CITY OF PORTLAND

October 6, 2003

RE: Site Plan Amendment, 1000 Brighton Avenue
Job ID#2003-0175, CBL #243-B-043

This letter is to confirm the revision to the approved site plan of the Forest City Chevrolet project located at 1000 Brighton Avenue. The approved revision includes exterior stairway, grading changes and parking reconfiguration. The revised plan has been reviewed and approved by the project review staff including representatives of the Planning, Public Works, Building Inspections, Fire and Parks Departments, with the following conditions:

CONCRETE CATCH BASIN

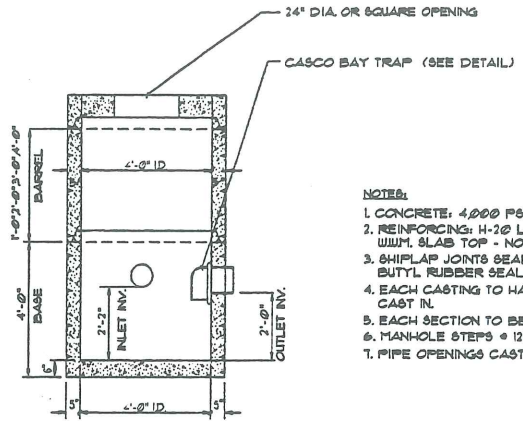
1. Stormwater calculations or analysis performed by an engineer shall be submitted stating that there is capacity in the pipe system either with or without a surcharge condition.
2. Each catch basin shall be installed with a casco trap, and the existing line to the outfall into Webb Street shall be cleaned of all and any siment or debris.
3. The applicant shall submit to the Planning Division and Public Works Department, an as-built, record drawing of all the drainage and utilities on the site upon completion.
4. Any work within the City's right-of-way shall be the responsibility of Forest City Chevrolet.
